## Appeal Decision

**Appeal Ref: APP/R5510/W/25/3364331**

**34 Oxford Avenue, Hayes UB3 5HY**

- The appeal is made under section 78 of the Town and Country Planning Act 1990 (as amended) against a refusal to grant planning permission.
- The appeal is made by Tejinder Kaur against the decision of the Council of the London Borough of Hillingdon.
- The application ref. is 77765/APP/2025/367.
- The development proposed is to use existing outbuilding as granny annexe.

Proposed Ground Floor Plan

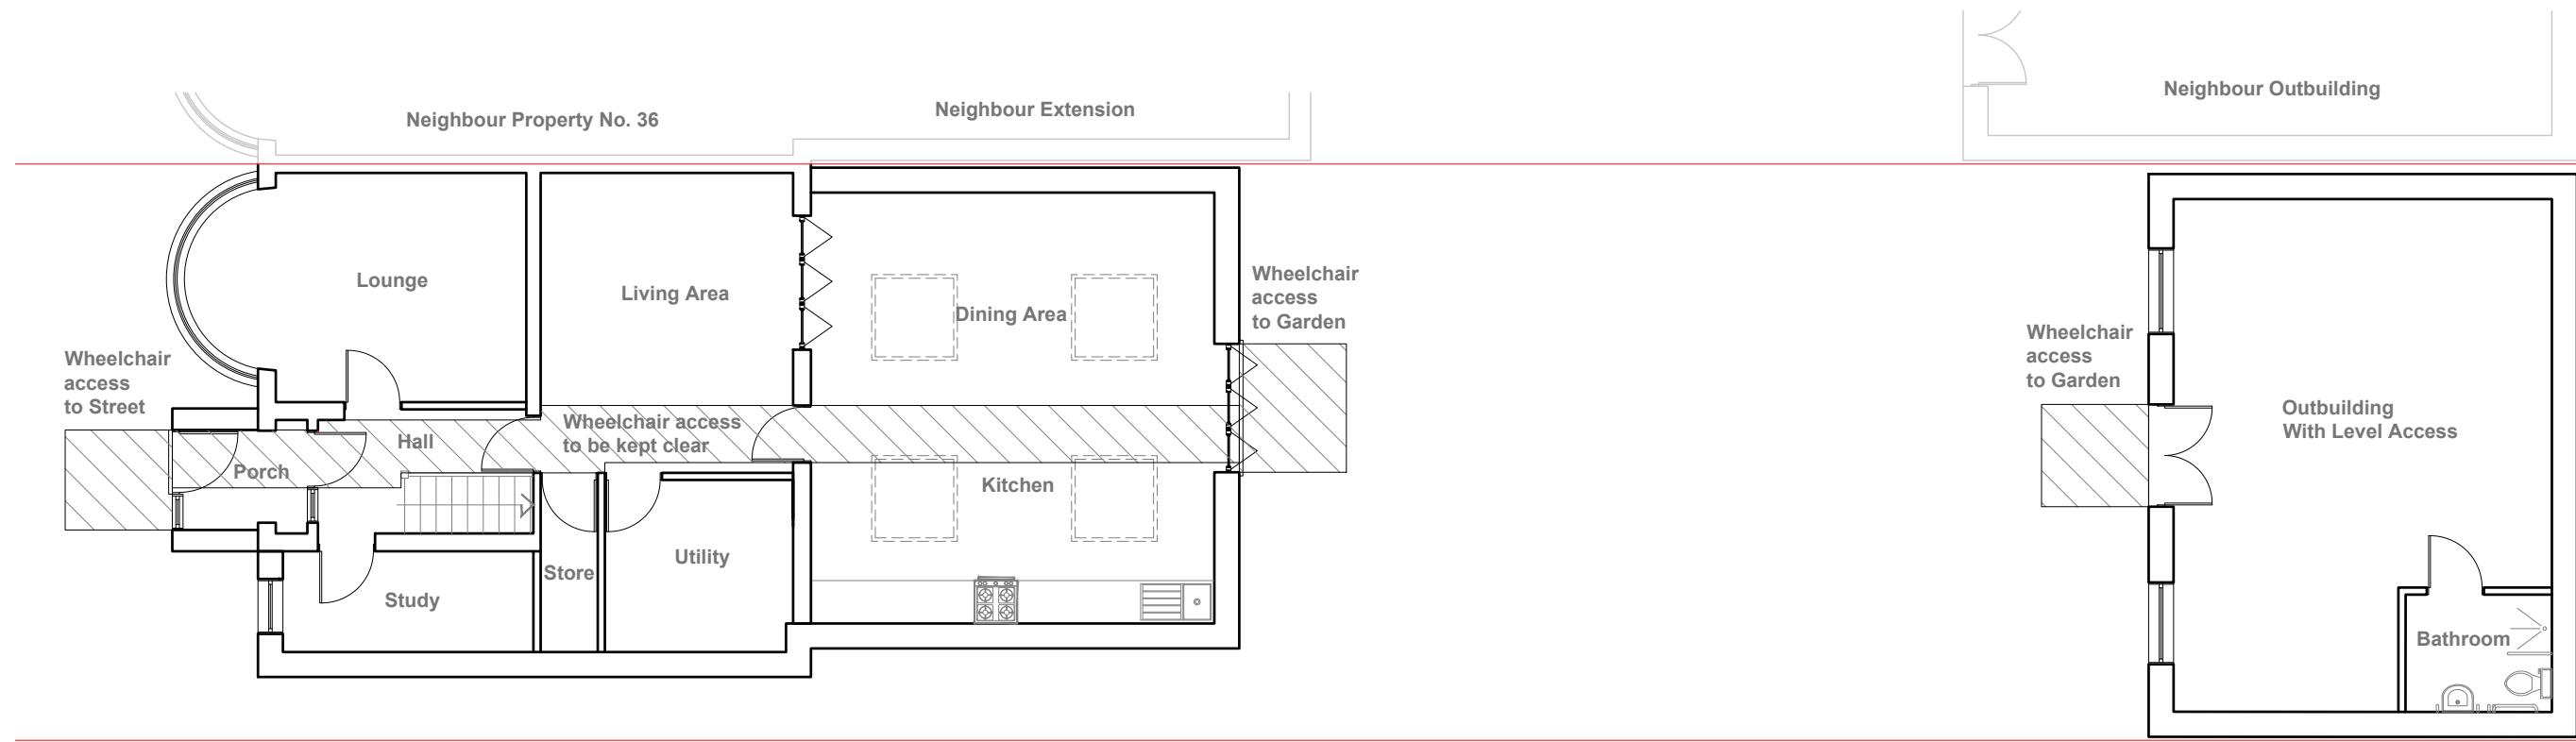
2. The Council used a different description of development on its decision notice to that on the application form. As it is not clear that the appellant agreed to this change, I have used the description on the application form.
3. I saw on site that a bathroom and rooflights had been installed in the outbuilding. The bathroom was in a different location to that shown on the drawings and the rooflights are not shown, so I have not treated the appeal as retrospective.

7. The proposal would convert the outbuilding into living accommodation and install ramps. Whilst the drawings only show a small bathroom, the remainder of the space unplanned, the appellant refers in evidence to the need for a bedroom and to kitchen elements. Together, these comprise all the facilities required for day-to-day living and would enable the outbuilding to function as a separate dwelling, particularly as there is no need to access it through the main house.

10. Both parties suggest that the outbuilding has an area of 47sqm, but the drawings show an area of about 38sqm. In any event, the proposal would adapt an existing outbuilding in such a way as to enable it to function as a separate dwelling. Whilst the floor area is still adequate for a 1-bed, 1-person, single-storey unit with shower room, a future occupier would have outlook from only two windows and doors all facing windows and doors in the rear extension, about 12 metres away.

Proposed Front Elevation (No Change)

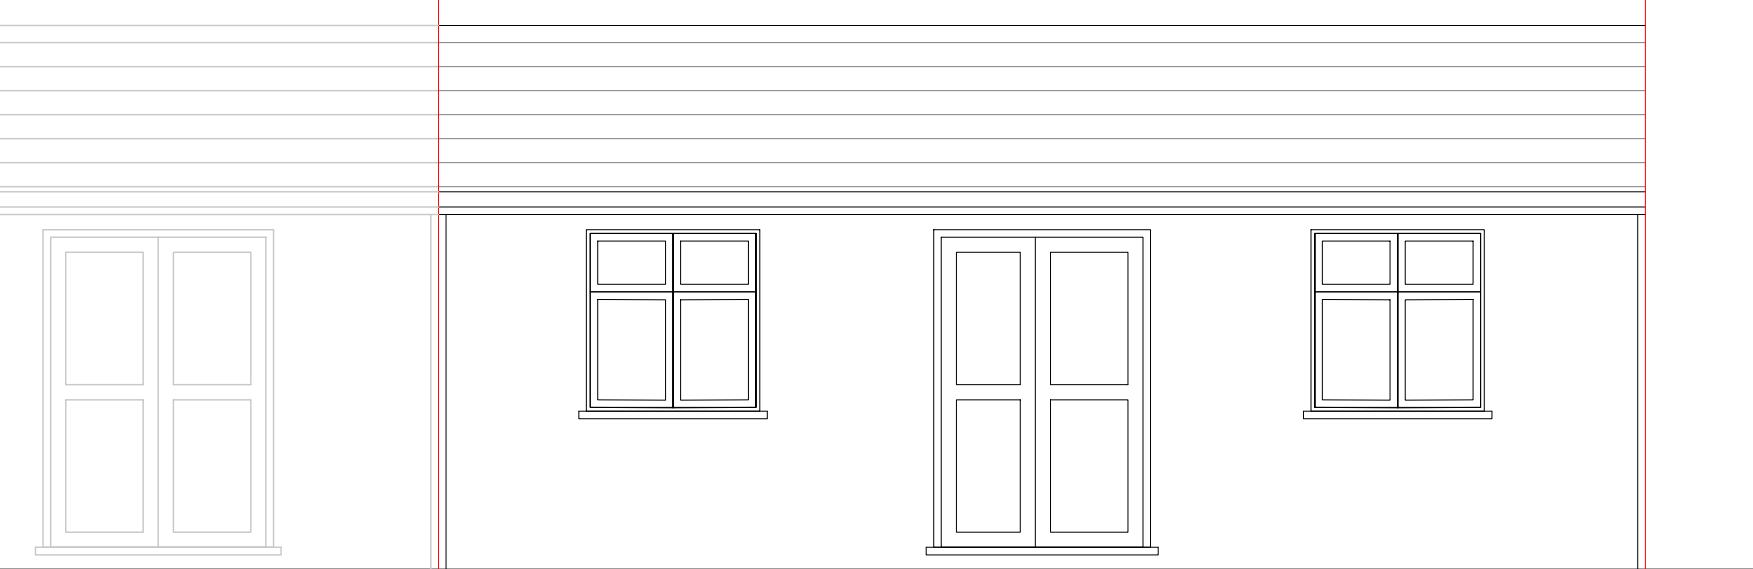
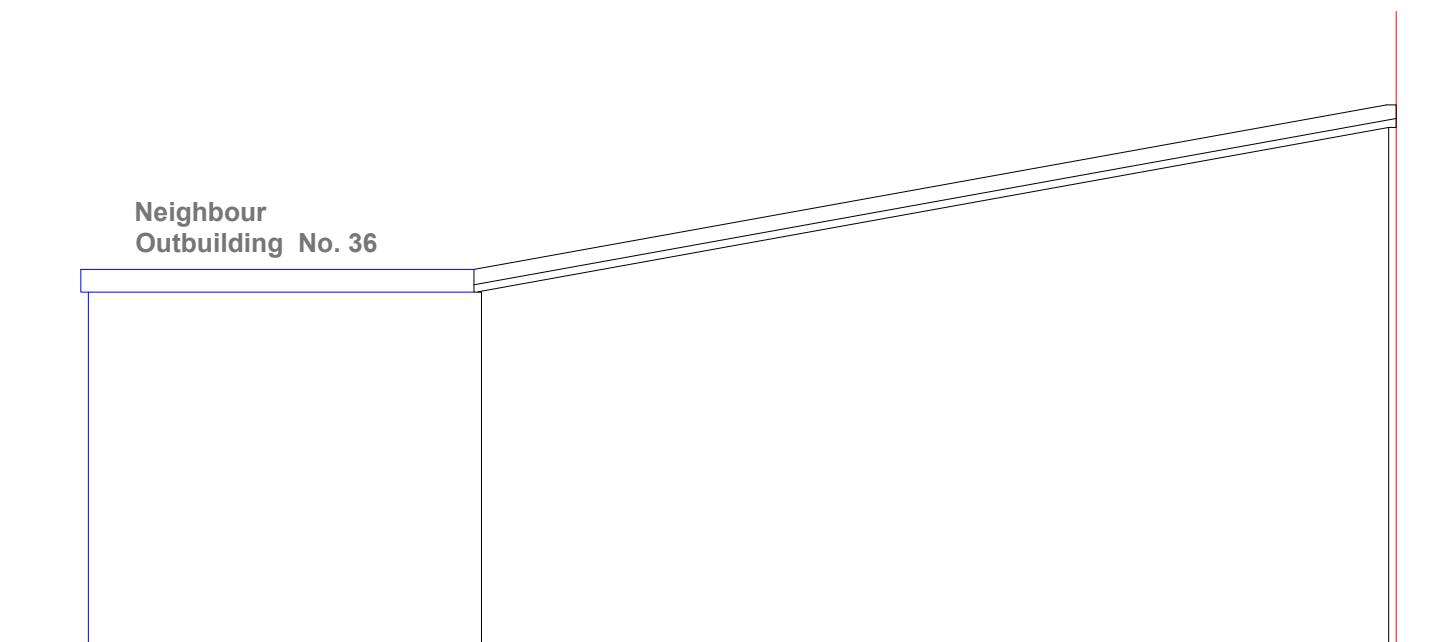
17. The appellant also suggests a condition to obscure glazing, but as I have found that the outlook afforded a future occupier would be inadequate, this would only increase that harm, even if it alleviated privacy concerns.
